# **M3 Junction 9 Improvement**

**Scheme Number: TR010055**

## **7.12.2 Statement of Common Ground with South Downs National Park Authority**

**27 October 2023**

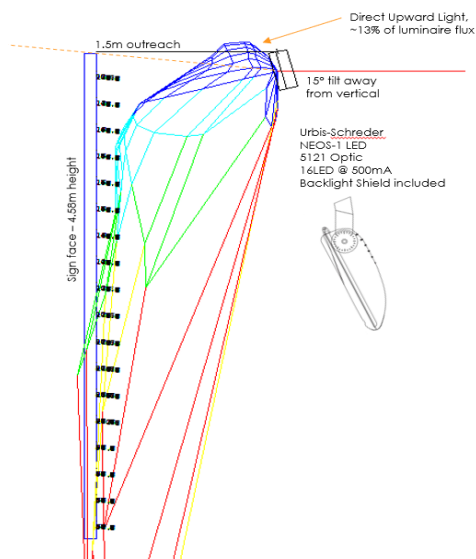
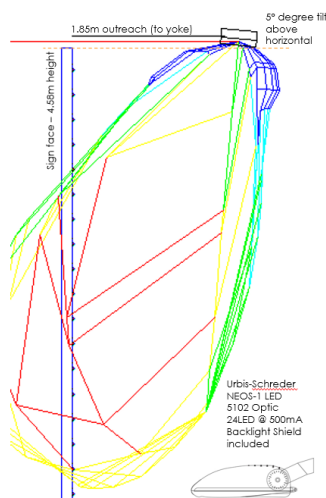
5.3	<b>Assessment methodology</b> Lighting, including Dark Night Skies	<b>Chapter 7 (Landscape and Visual) of the Environmental Statement (ES) (6.1, Rev 1), Appendix 7.7 (Technical Note Lighting Assessment)</b>	<b>15 June 2023</b> As set out in Paragraph 6.23 of our Local Impact Report (REP2-071). The SDNPA welcomes the general approach by the applicant to avoid and minimise the impacts of lighting and the statement, including the commitments in the First Iteration Environmental Management Plan (application	<b>17 July 2023</b> Following discussion at Issue Specific Hearing 1 (ISH1), National Highways updated <b>Figure 7.14 of Chapter 7 (Landscape and Visual – Figures) (Part 3 of 3) (6.2, Rev 1)</b> .	Not agreed	25 October 2023

**FIGURE 9A**  
*Environmental Masterplan & LVIA Viewpoints*

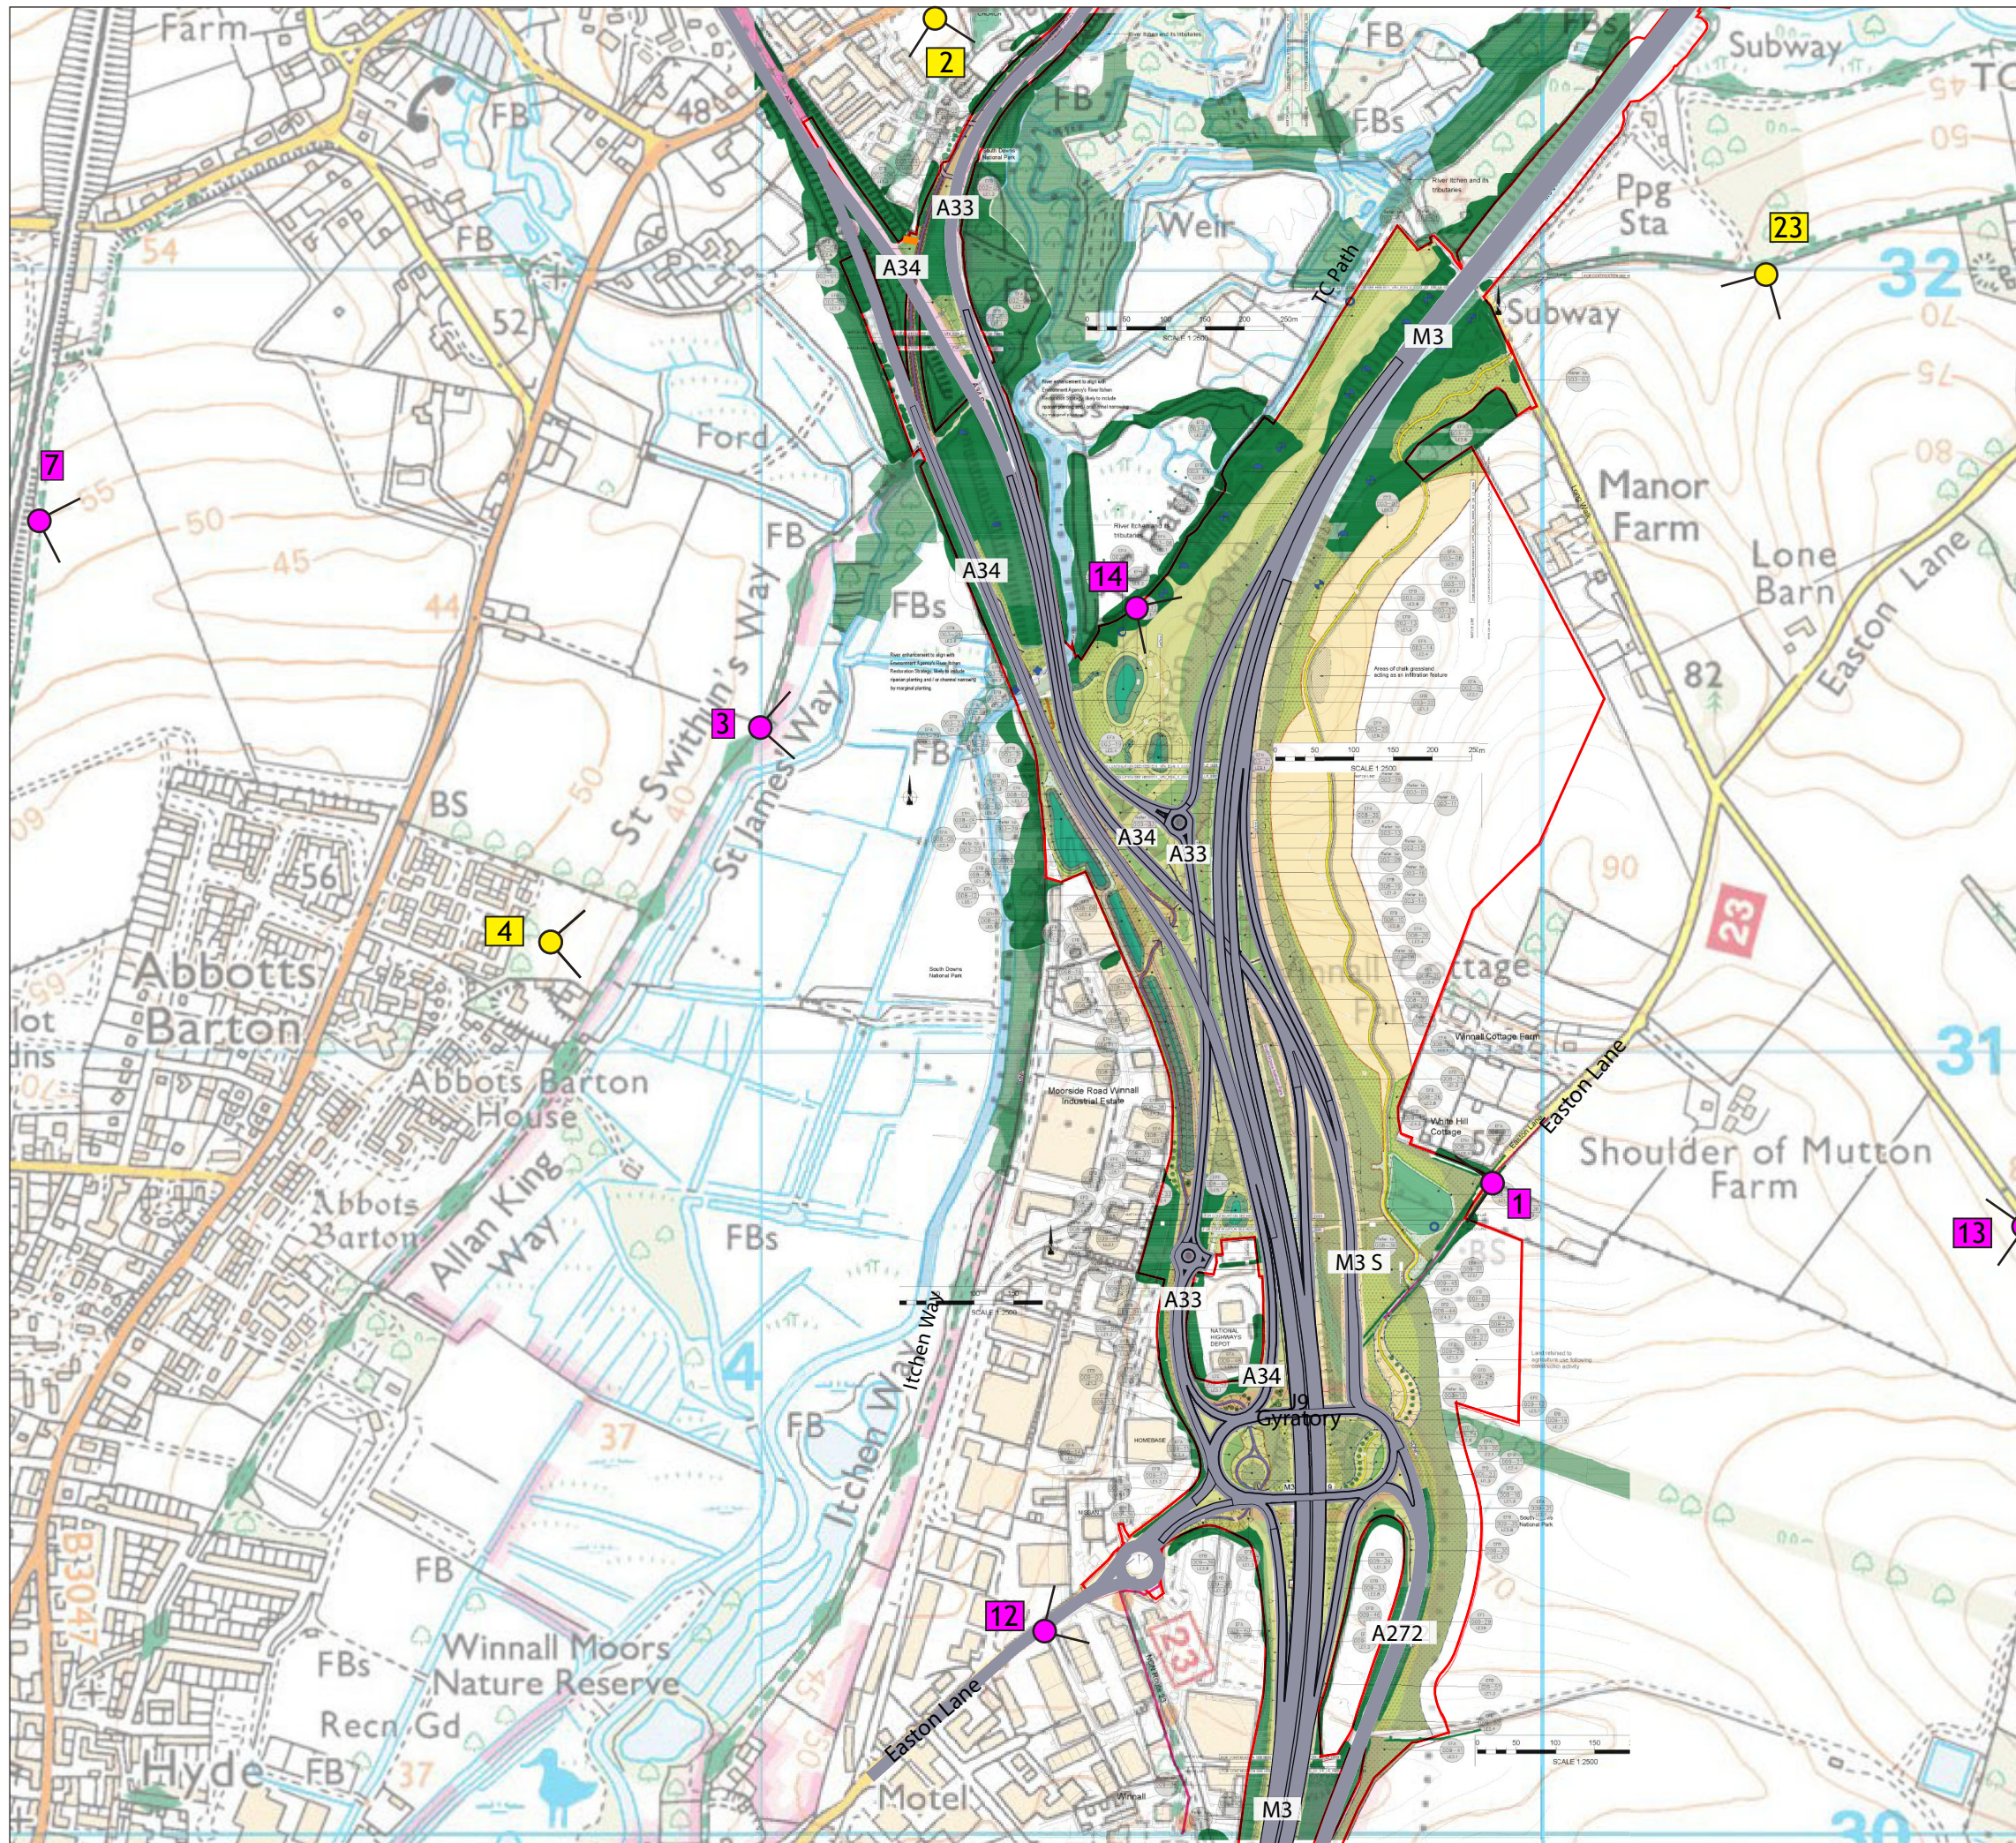
2.4	<b>Application Boundary</b> Chalk grassland and farmland interface Cart and Horses junction	<b>Figure 2.3 (Environmental Masterplan) in Chapter 2 (The Scheme and its Surroundings – Figures (Part 2 of 4)) of the ES (6.2, Rev 1), South Downs National Park Authority's Local Impact Report (LIR) (REP2-071) and Written Representation (REP2-075) and Applicant responses</b>	<b>15 June 2023</b> See paragraphs 6.14(e) and 6.32 of our Local Impact Report (REP2-071) and 3.1.17(e) and 3.2.1(a) of our Written Representation (REP2-075), which highlight two issues: <ul style="list-style-type: none"> <li>▪ Chalk grassland and farmland interface</li> <li>▪ The exclusion of the Cart and Horses Junction</li> </ul>	Assurance of mitigation and compensation would be secured through the DCO with reference to <b>Figure 2.3 (Environmental Masterplan) in Chapter 2 (The Scheme and its Surroundings – Figures (Part 2 of 4)) of the ES (6.2, Rev 1)</b> . The Cart and Horses junction is outside the Application Boundary and no work is proposed to the junction as part of the Scheme. <b>17 July 2023</b> National Highways position is stated in <b>Applicant comments on Local Impact Reports (8.9, REP3-023)</b> , response to paragraph 6.14(e) of South Downs National Park Authority's LIR ( <b>REP2-071</b> ). National Highways' position with respect to the Cart and Horses junction is outlined in <b>Appendix A</b> of the	<b>Not agreed</b>	21 July 2023
